# East West Rail Phase 2

### Stage 2 Road safety audit response report

### Offline Highways Passing Places – Package 2 – Oxfordshire (A3 Marsh Gibbon – Compound Access)

**Document Number: 133735\_RW-EWR-XX-XX-RP-CH-000049**

Drawing Number  
133735\_2A-EWR-OXD-A3\_P\_9-DR-CH-010001

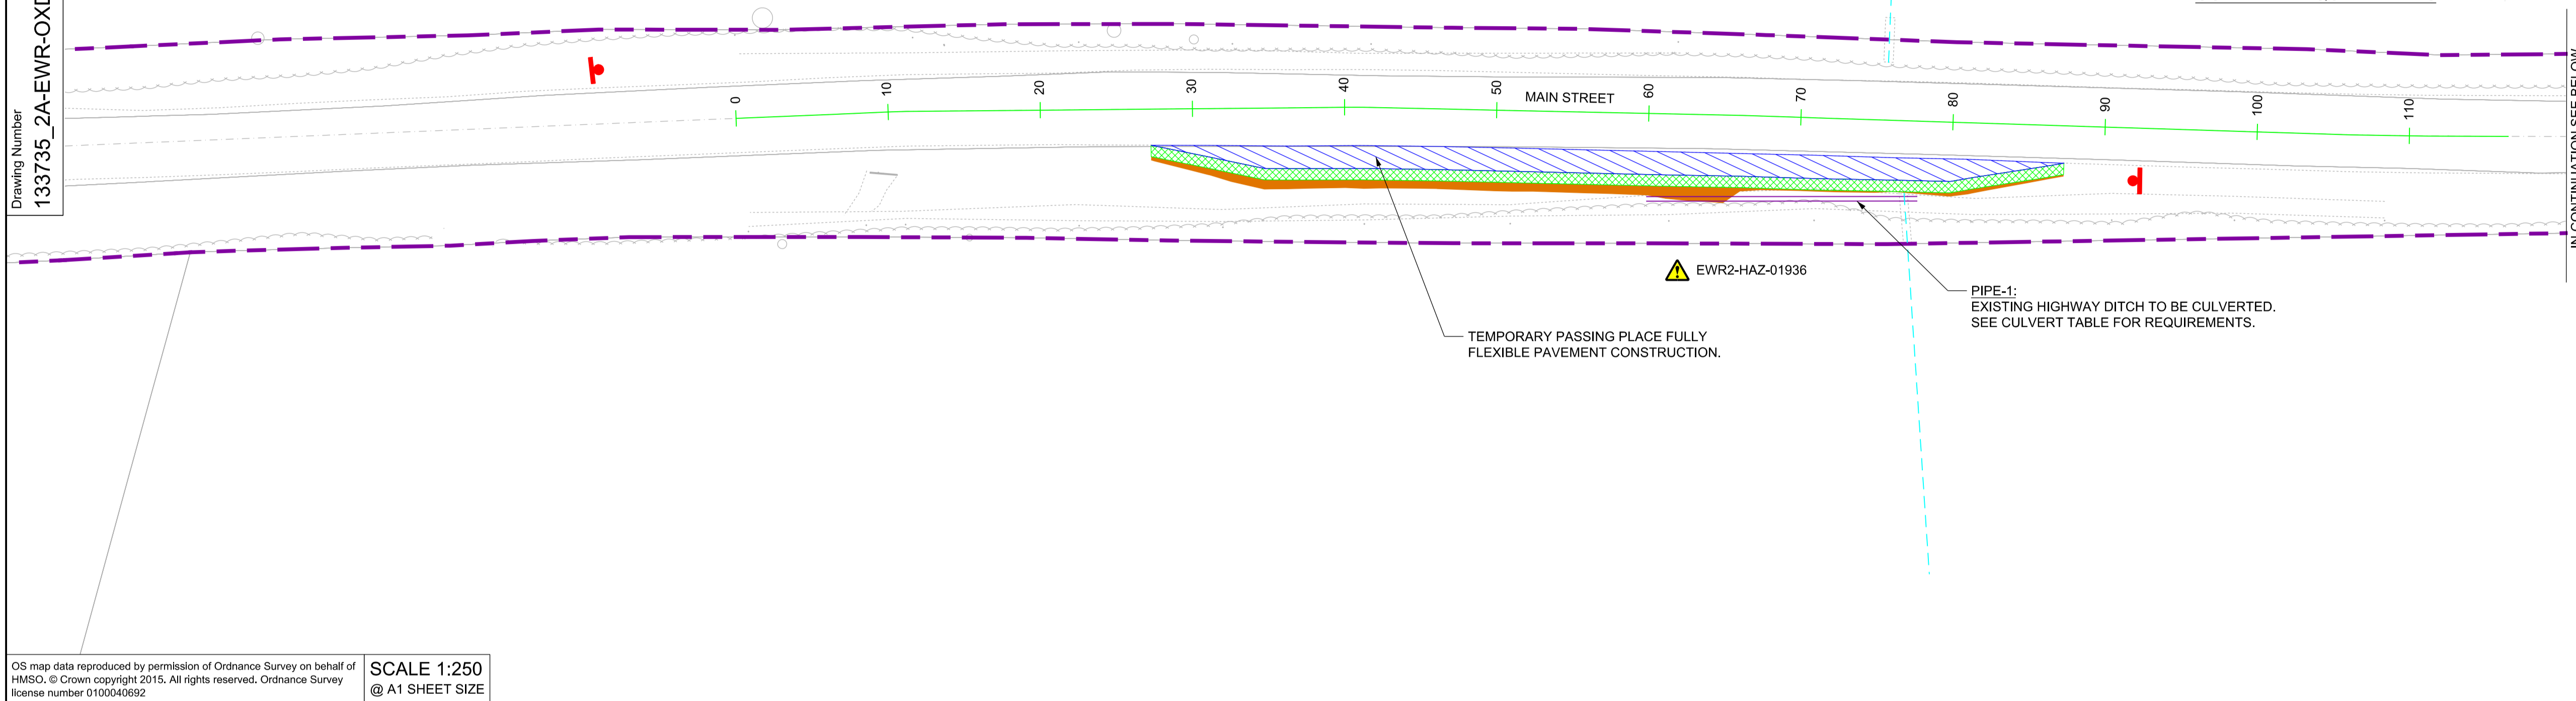
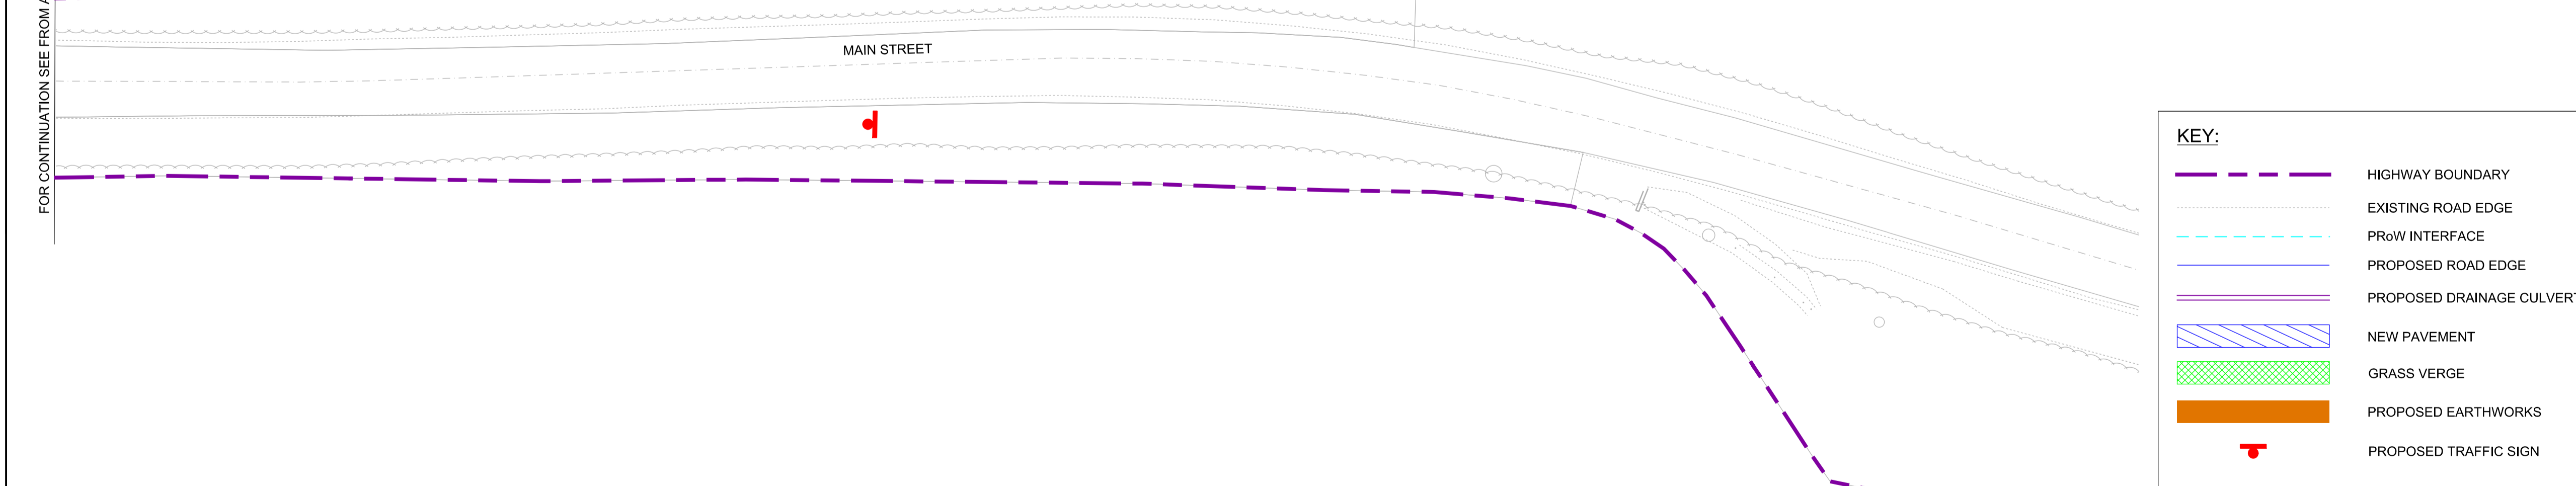
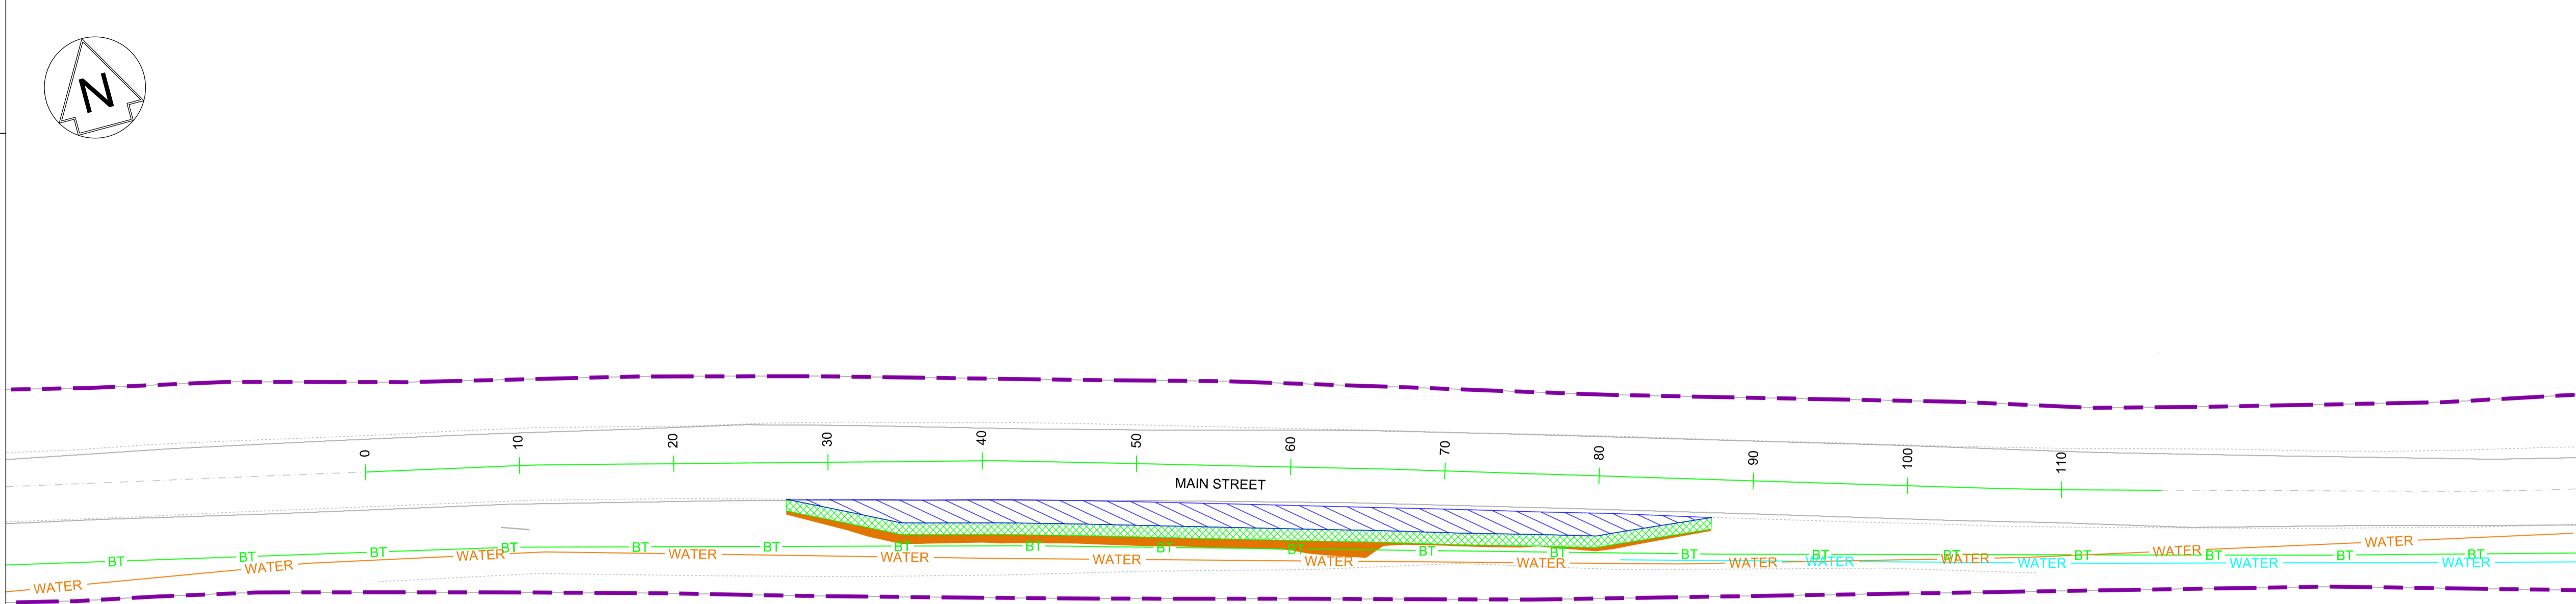
**A3-P-9, Unnamed Road (towards Mill Road)** – Move passing place A3-P-9 further downstream heading westbound towards passing place A3-P-8. Provide traffic signing to warn pedestrians and construction vehicles of the passing place and presence of pedestrians, respectively. Trim back vegetation around the access to maximise visibility between pedestrians and drivers.

<p>A3-P-9, Unnamed Road (towards Mill Road) – Move passing place A3-P-9 further downstream heading westbound towards passing place A3-P-8. Provide traffic signing to warn pedestrians and construction vehicles of the passing place and presence of pedestrians, respectively. Trim back vegetation around the access to maximise visibility between pedestrians and drivers.</p>	<p><b>Accept the RSA problem raised but suggest an alternative solution.</b></p> <p>Passing place to remain in proposed position in accordance with TWAO. Traffic signing to warn vehicles of the presence of pedestrians in advance of the public right of way interface shall be provided, on the eastbound approach and before A3-P-9 and on the westbound approach and before A3-P-9. The site clearance drawings shall include vegetation clearance around the public right of way interface to maximise visibility for pedestrians and drivers. The RSA recommendations with respect to warning signage for pedestrians accessing the carriageway from a public right of way will be shared with the logistics team for inclusion.</p>	Accepted	Proceed as Design Team Response

Drawing Title
**PASSING PLACE A2_P_8
EXISTING UTILITIES AND
SITE CLEARANCE**

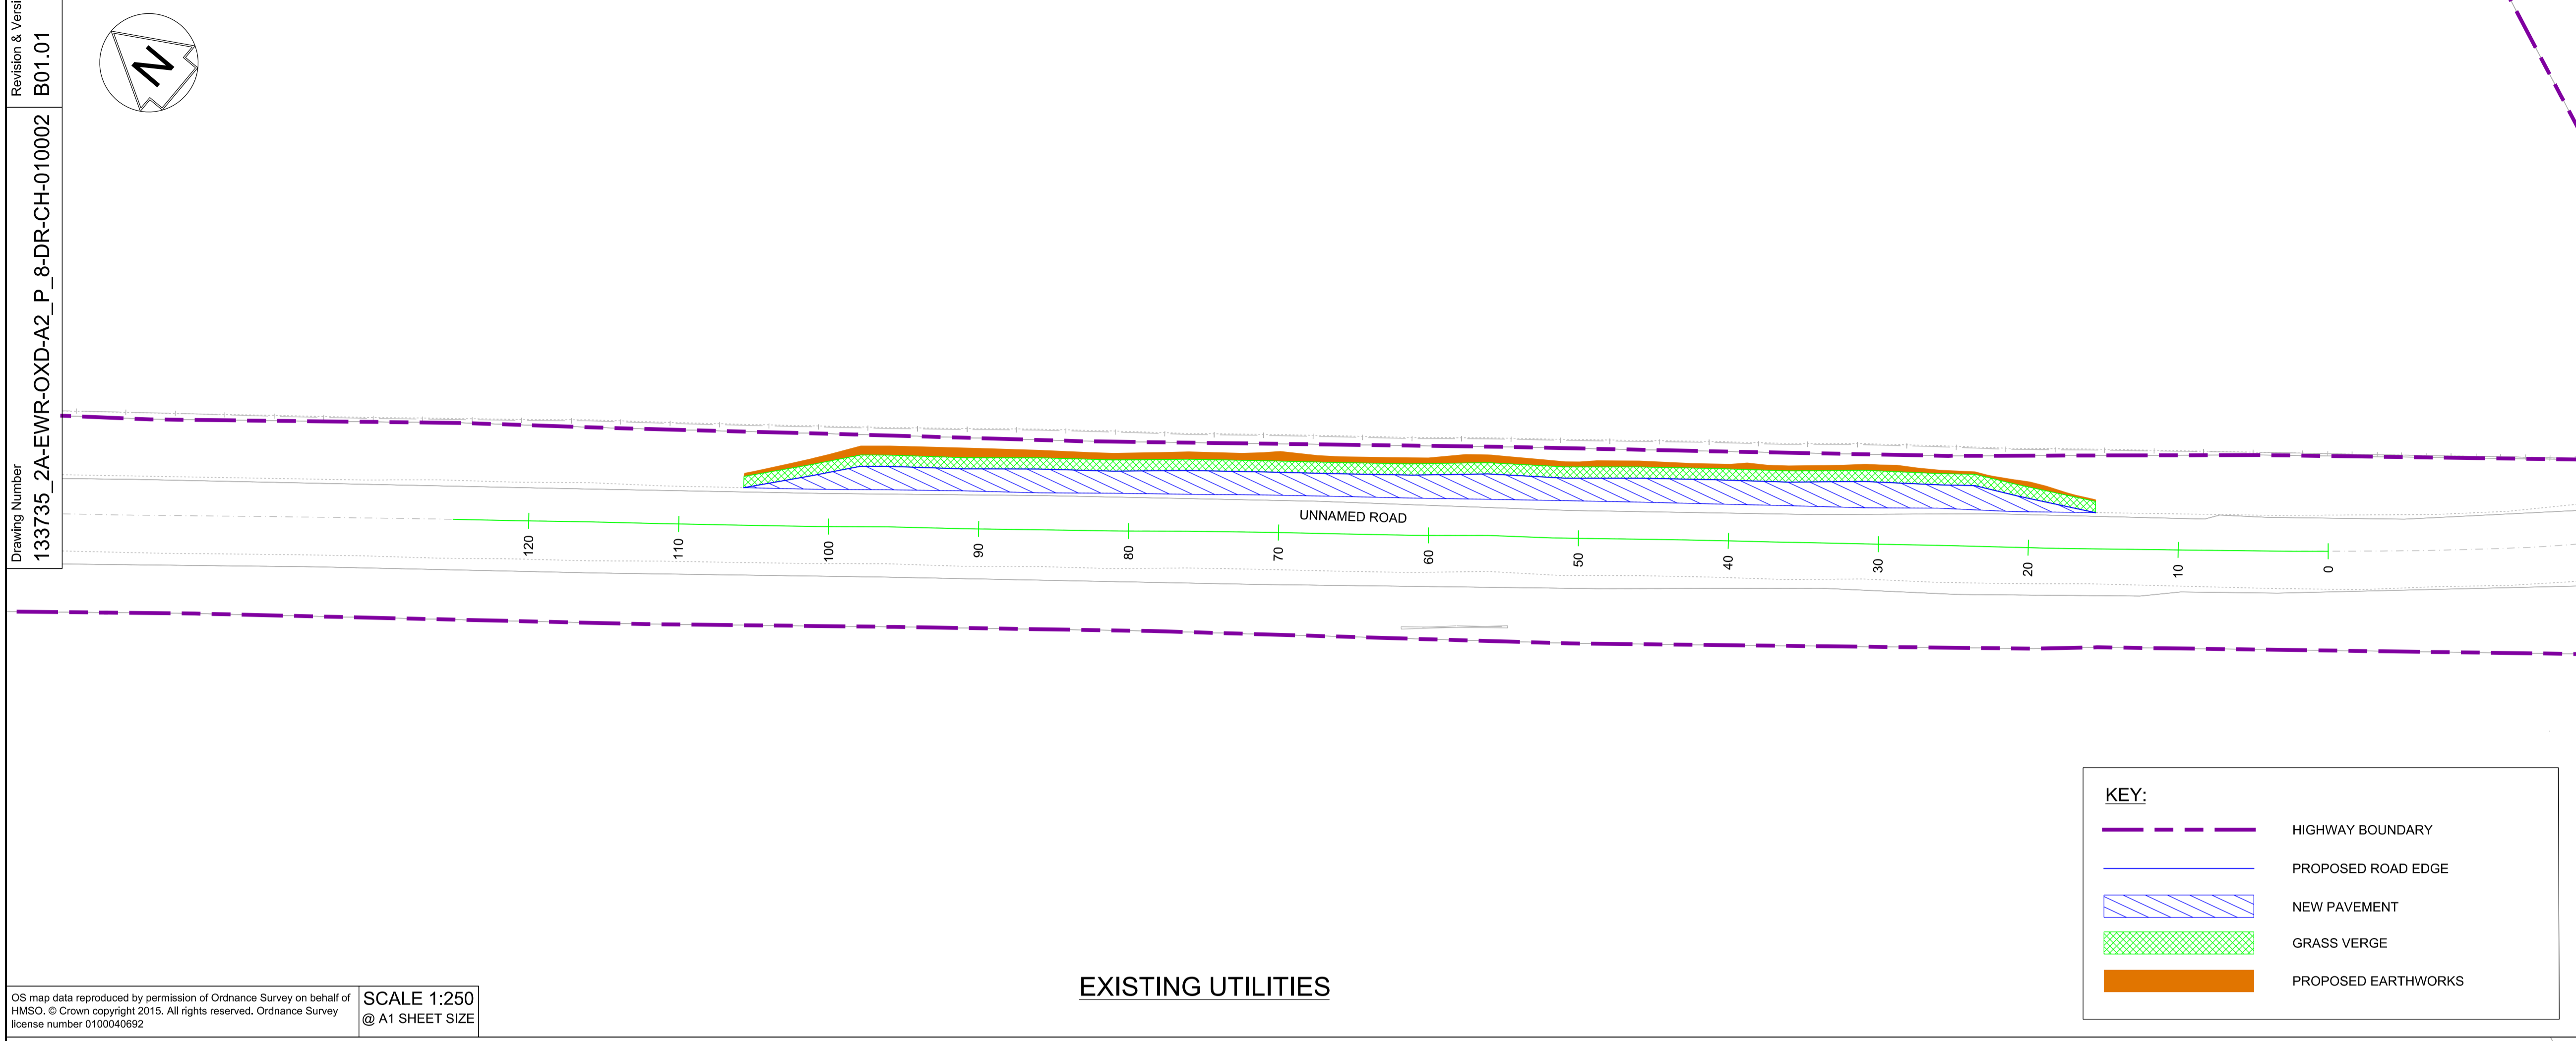
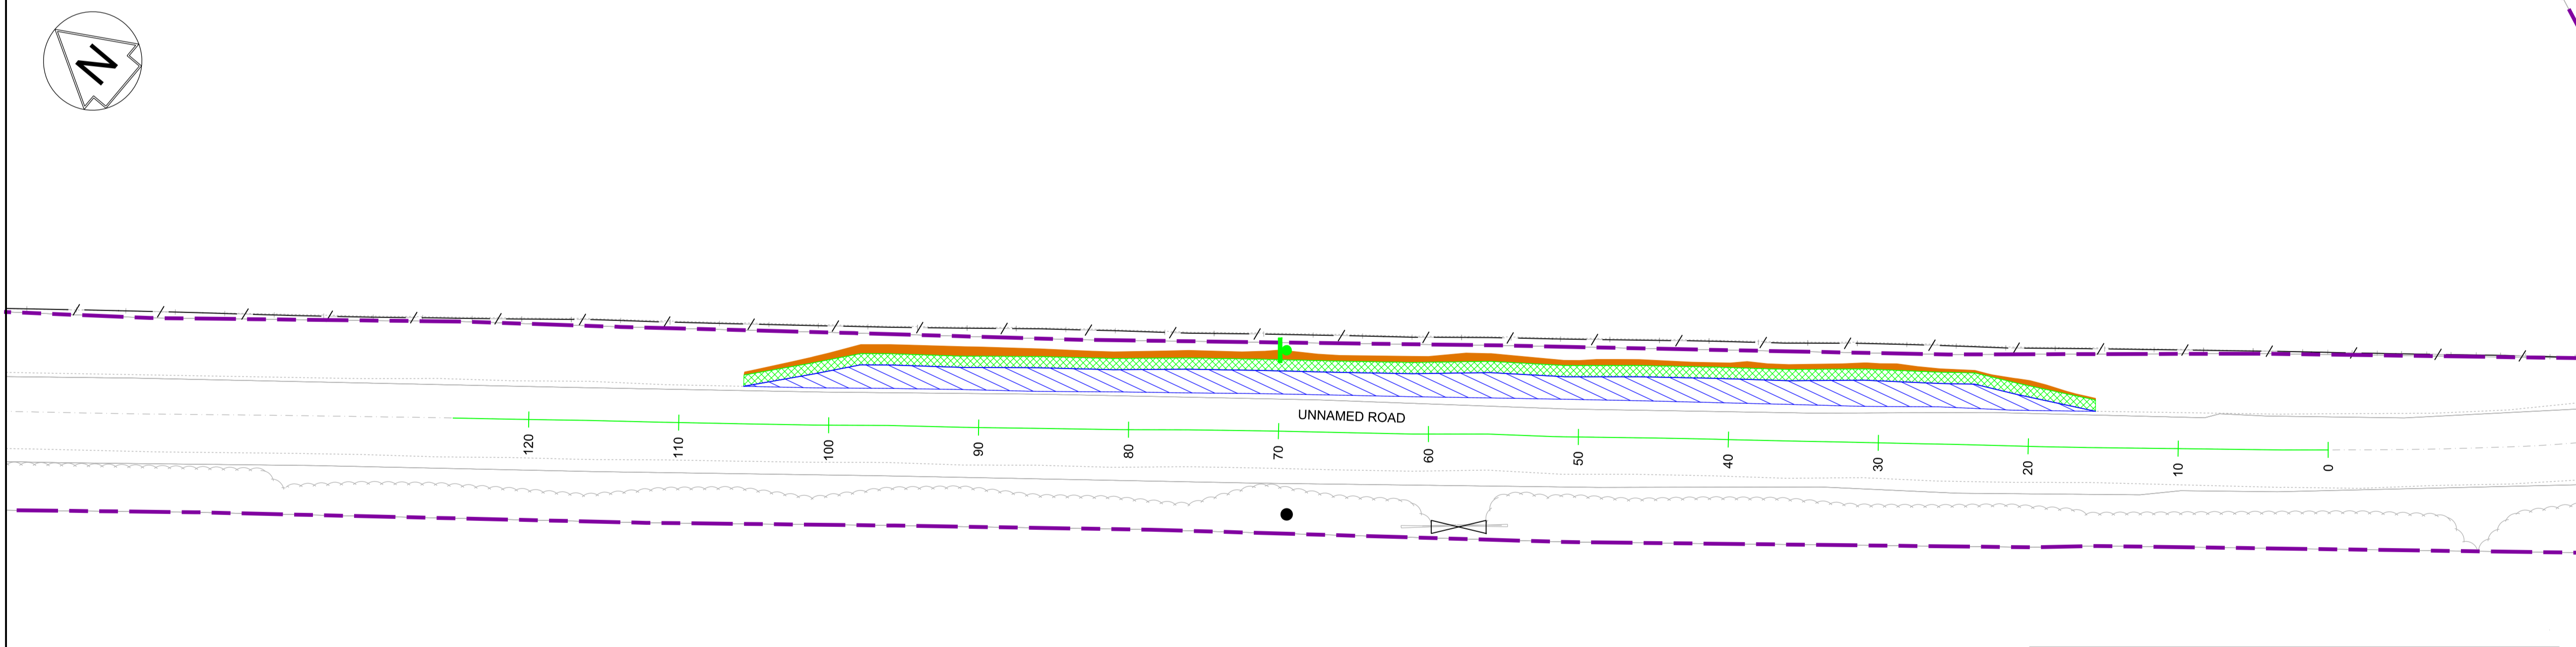
There is a disused signpost in the nearside verge heading westbound on Unnamed Road (towards Mill Road), opposite the proposed passing place A2-P-8, which presents an unnecessary hazard to a vehicle, should a collision occur at this location. The likelihood of a vehicle striking the disused signpost is increased by the location of the passing place opposite as vehicles may pass closer to the verge to avoid construction traffic. This disused signpost may therefore lead to an increase in the collision severity should one occur.

Remove disused signpost.

2.2	Passing Place A2-P-8. Unnamed Road (towards Mill Road).	<b>Disused signpost increases potential severity of collision</b> There is a disused signpost in the nearside verge heading westbound on Unnamed Road (towards Mill Road), opposite the proposed passing place A2-P-8, which presents an unnecessary hazard to a vehicle, should a collision occur at this location. The likelihood of a vehicle striking the disused signpost is increased by the location of the passing place opposite as vehicles may pass closer to the verge to avoid construction traffic. This disused signpost may therefore lead to an increase in the collision severity should one occur.	Remove disused signpost.	<b>Accept the RSA problem and recommendation made by the RSA team.</b> The disused signpost is included for removal in the Site Clearance Drawing.	Accepted	Proceed as Design Team Response
